Application No: K/51/21/PL
Site Address: 47 Golden Avenue East Preston BN16 1QX
Description of works: Erection of 1 No detached dwelling and integral garage. This site is in CIL Zone 4 and is CIL Liable as new dwelling.

Thank you for your internet representation made on 21st November 2021 which has been recorded as no objection with the comments as follows:

| DRAWING TITLE<br>Proposed Block Plan and Street<br>Scene                                                                     |                        |

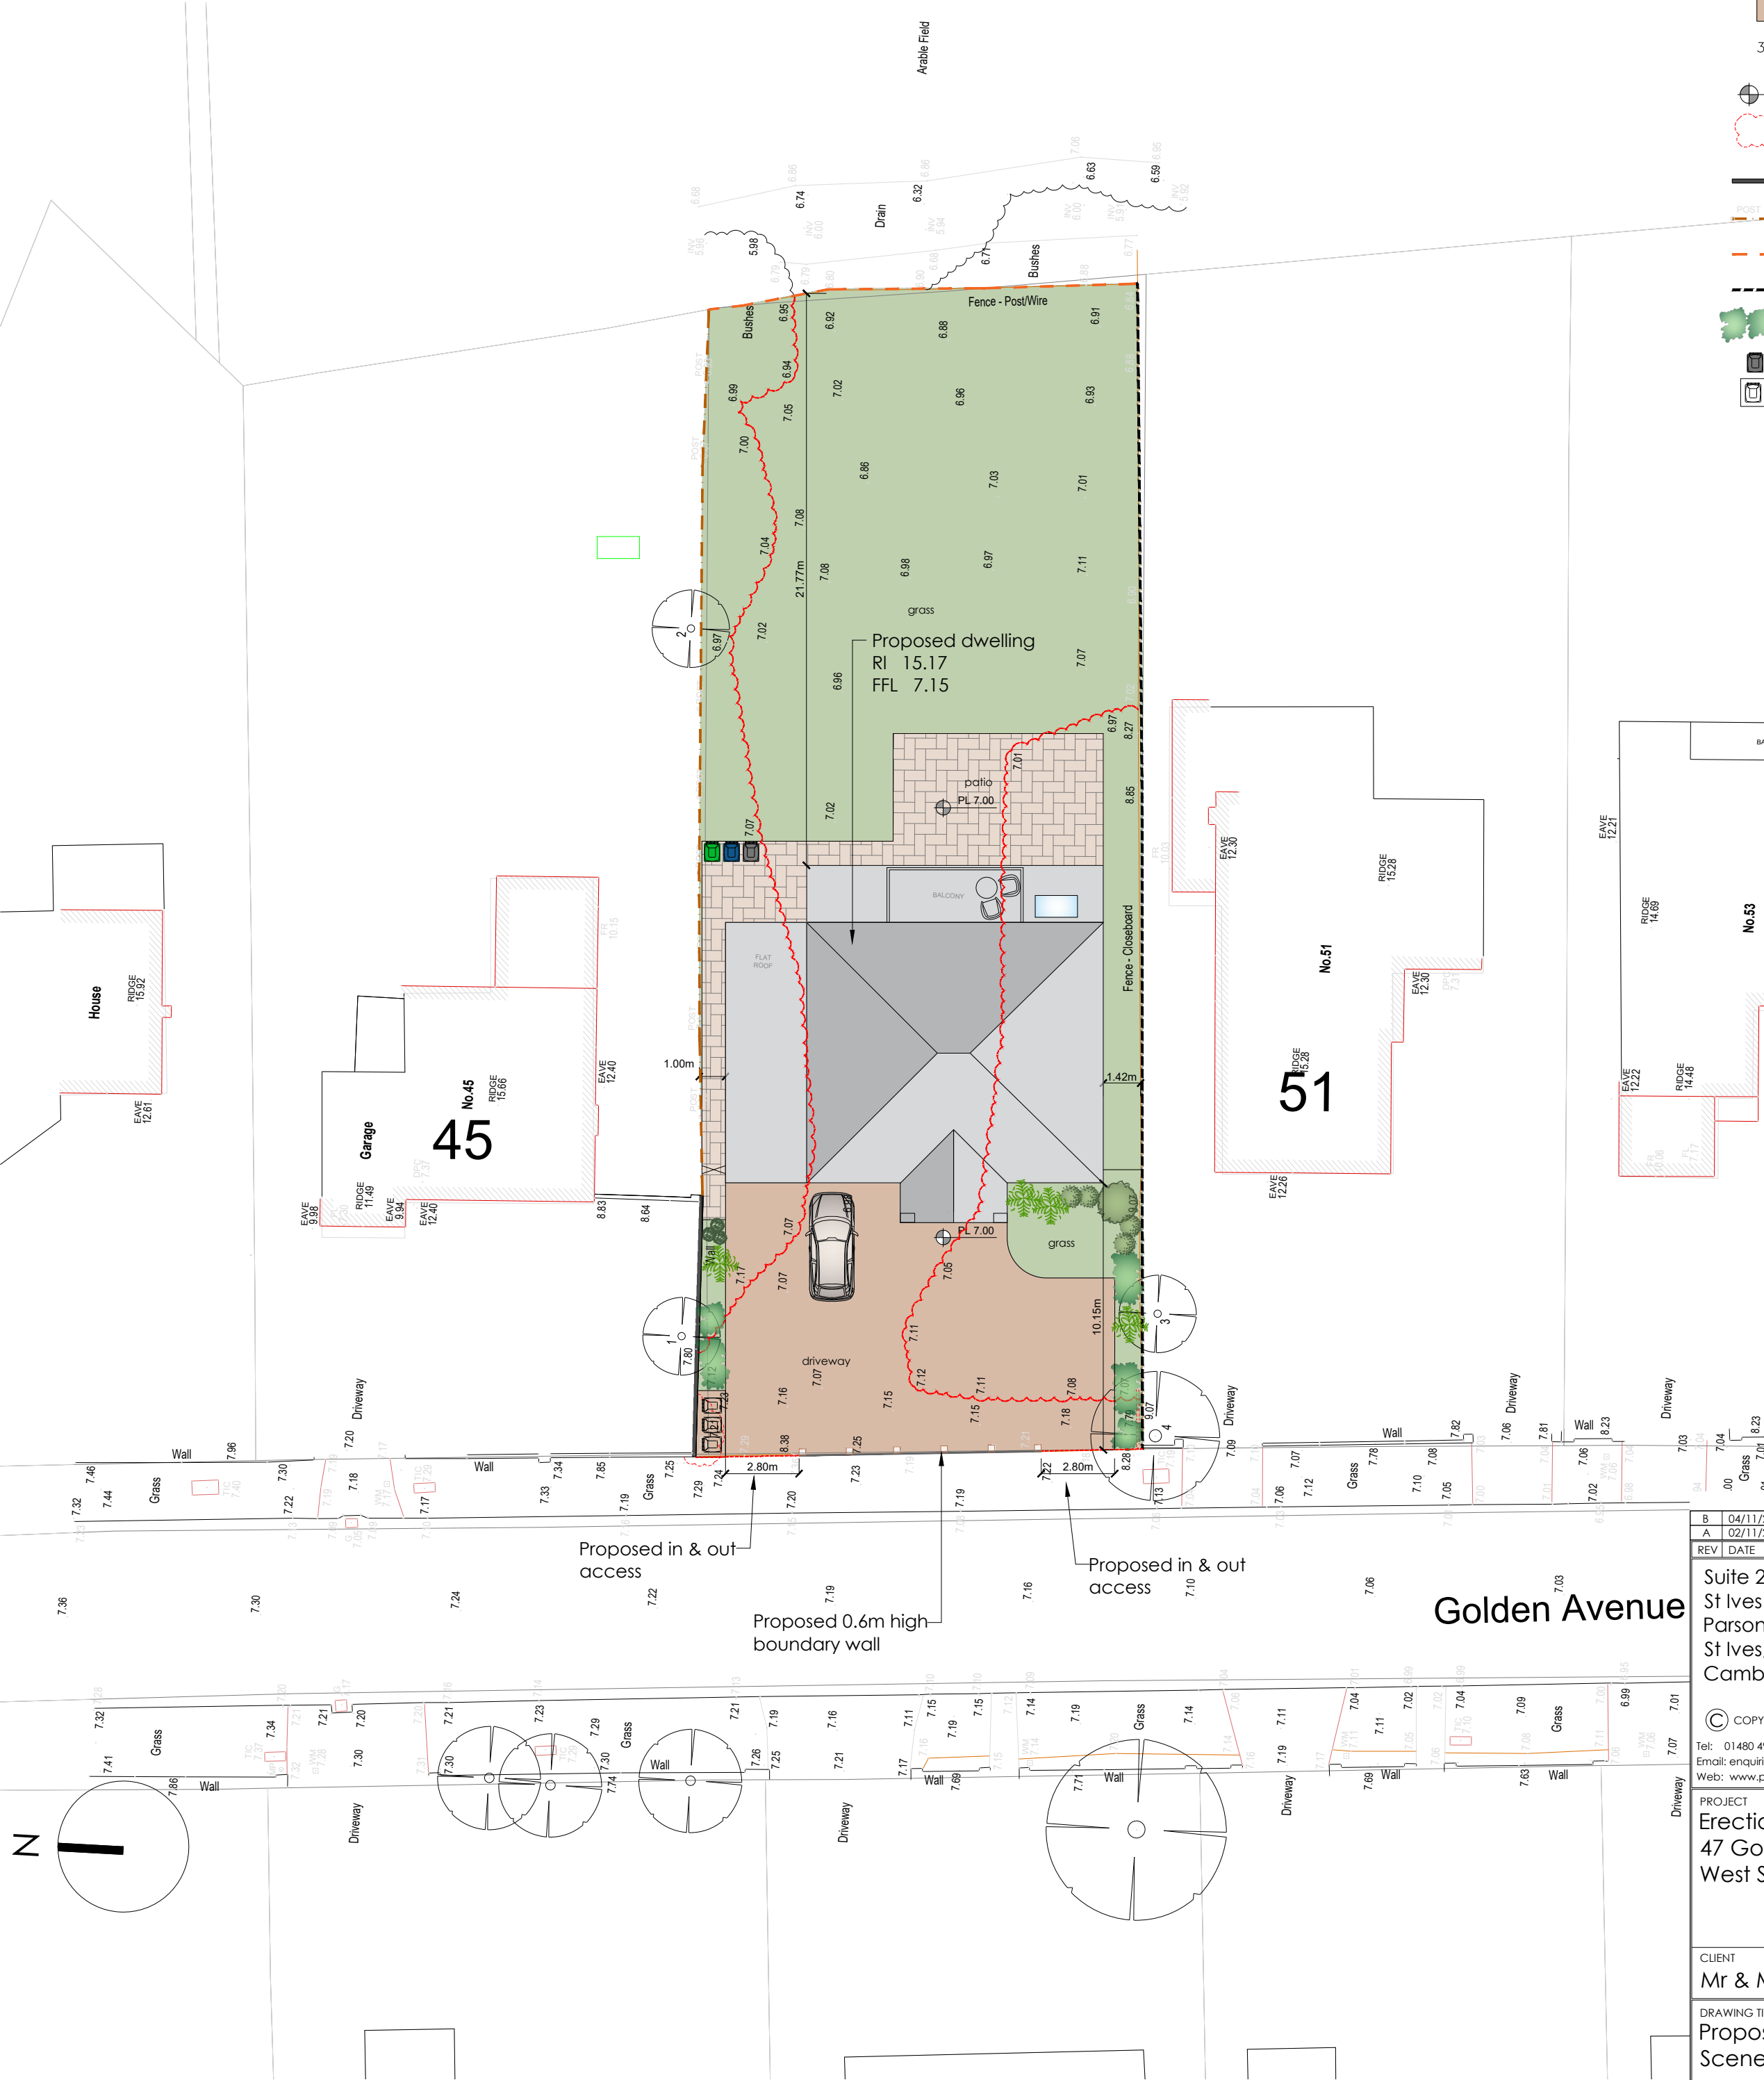
We have no objection, with the proviso that construction planning includes an obligation / condition requiring the installation of solid panel site hoarding between the plots of 45 and 47 Golden Avenue, at a suggested height of no less than 2.4 metres. We conclude that mesh fencing will not sufficiently limit the impact of hazards such as construction noise, dust, and vibration on our family. The hoarding can be foundation free surface mounted or dug in, but it needs to comply with both BS EN 1991 for Wind Loading and TWf2001 for best practice in temporary works.
